PLANNING CONSULTATION RESPONSE

Application No	2026/0657
Proposal	Erection of 1no. building for industrial (class E(g)(iii)/B2) or storage and distribution (class B8) use with associated yard, parking, landform and landscaping (Reserved matters of the outline part of hybrid planning permission 2019/1573) for Unit 6 seeking approval of access, appearance, landscaping, layout and scale.
Address	Land to the north and south of Dearne Valley Parkway, Hoyland, Barnsley
Date of Consultation Reply	09/09/2025
Consultee	Katie Lawrence, Planning Ecologist

| number  | FIGURE 1           | rev       | -            |

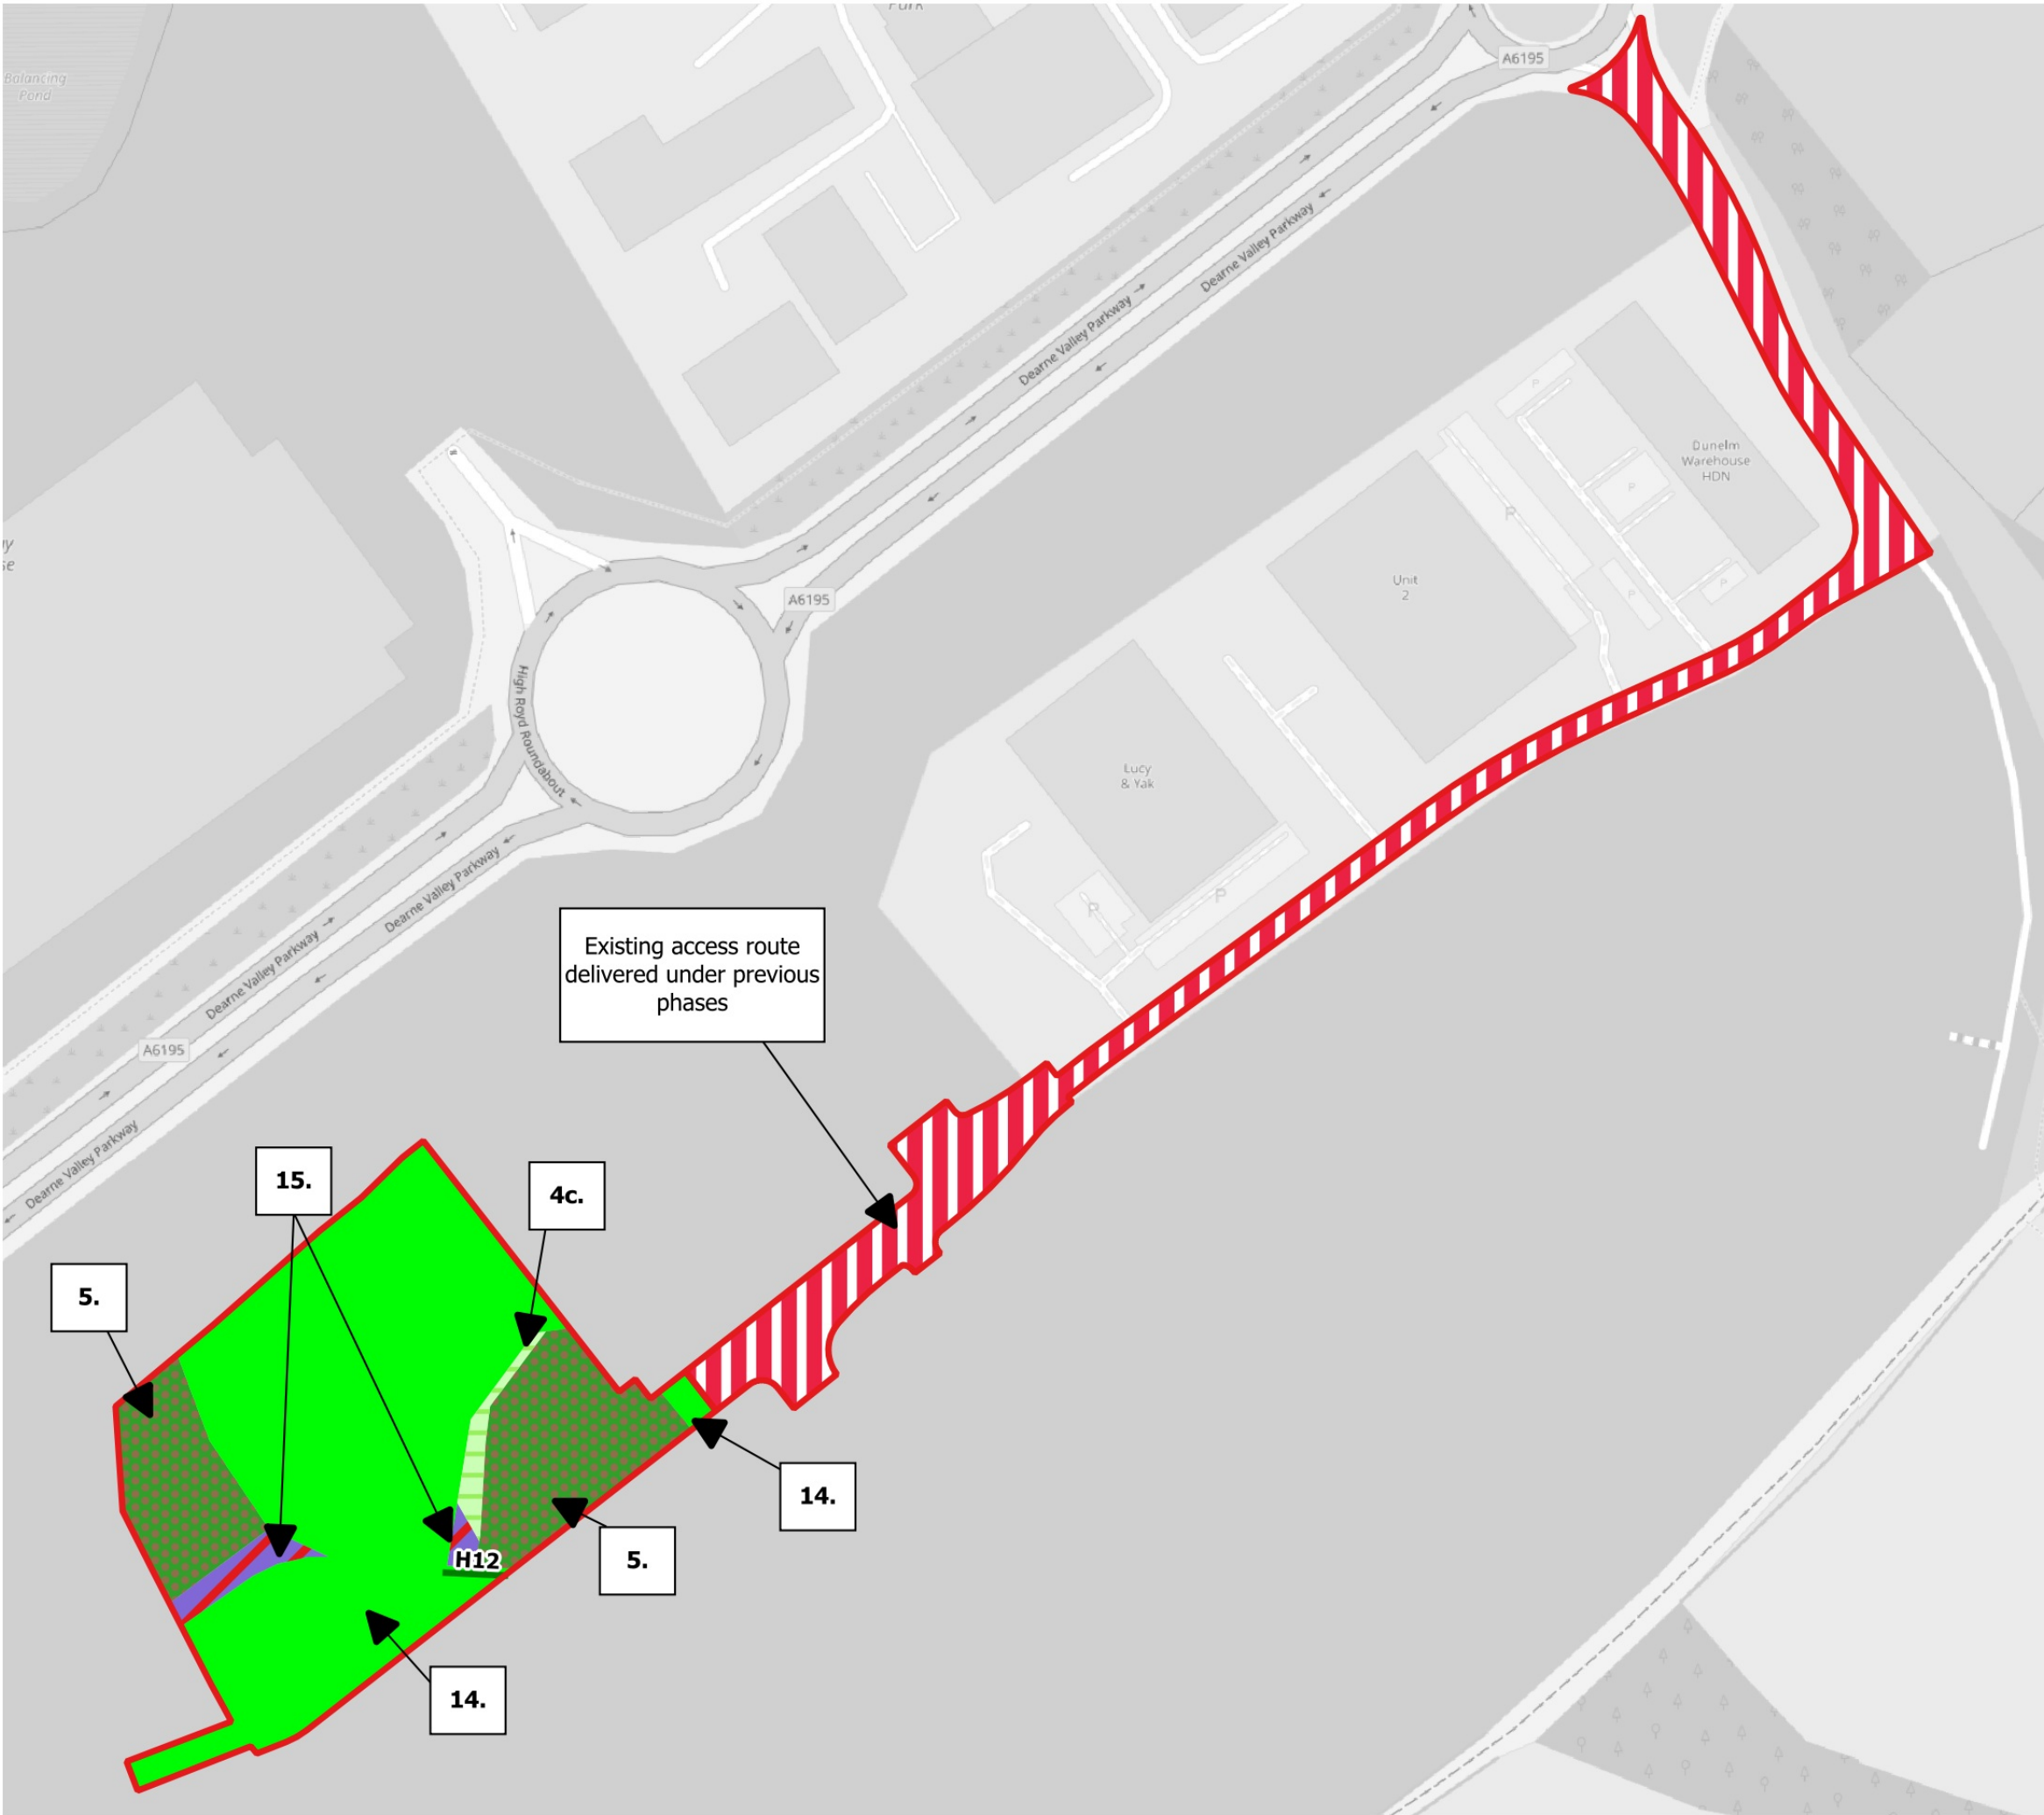
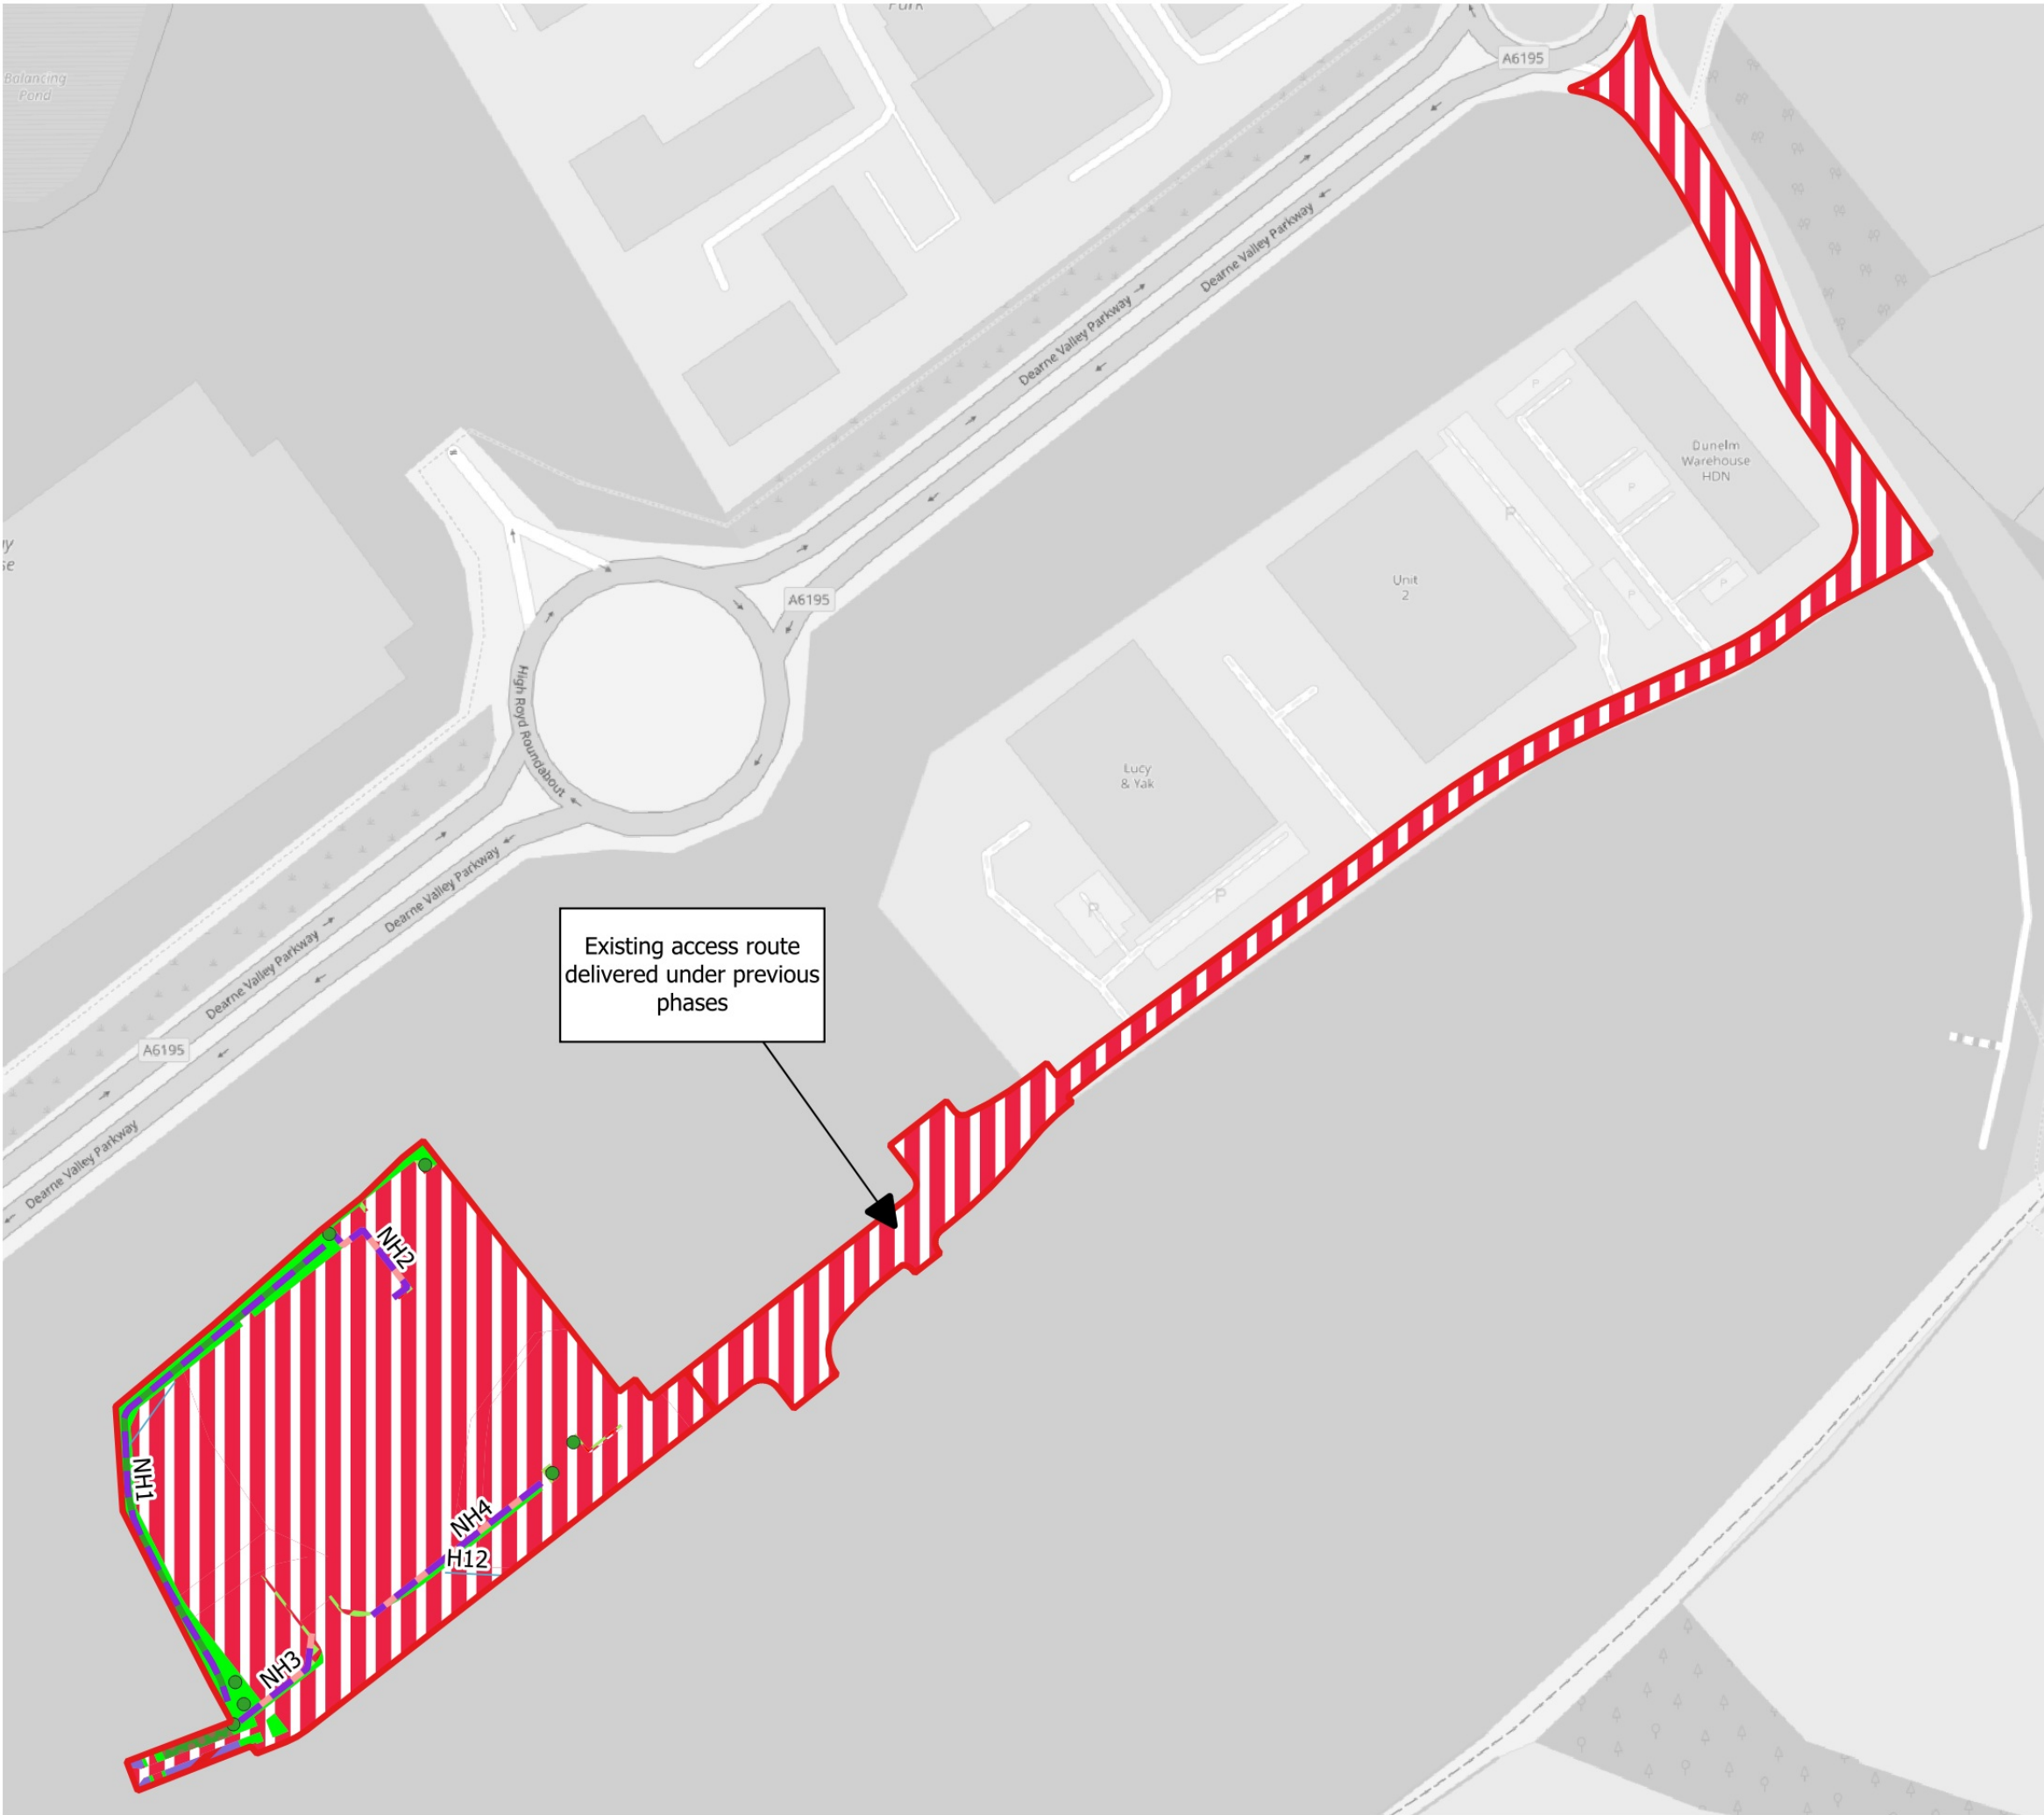
Figure 1 of the document shows the proposed location of the bird and bat boxes; however, it does not show locations for the log piles. Can this be added? It is shown on the proposed landscape plan (drawing no. 12006-6-SFW-XX-XX-DR-L-1001) but would ideally be included on figure 1 for completeness.
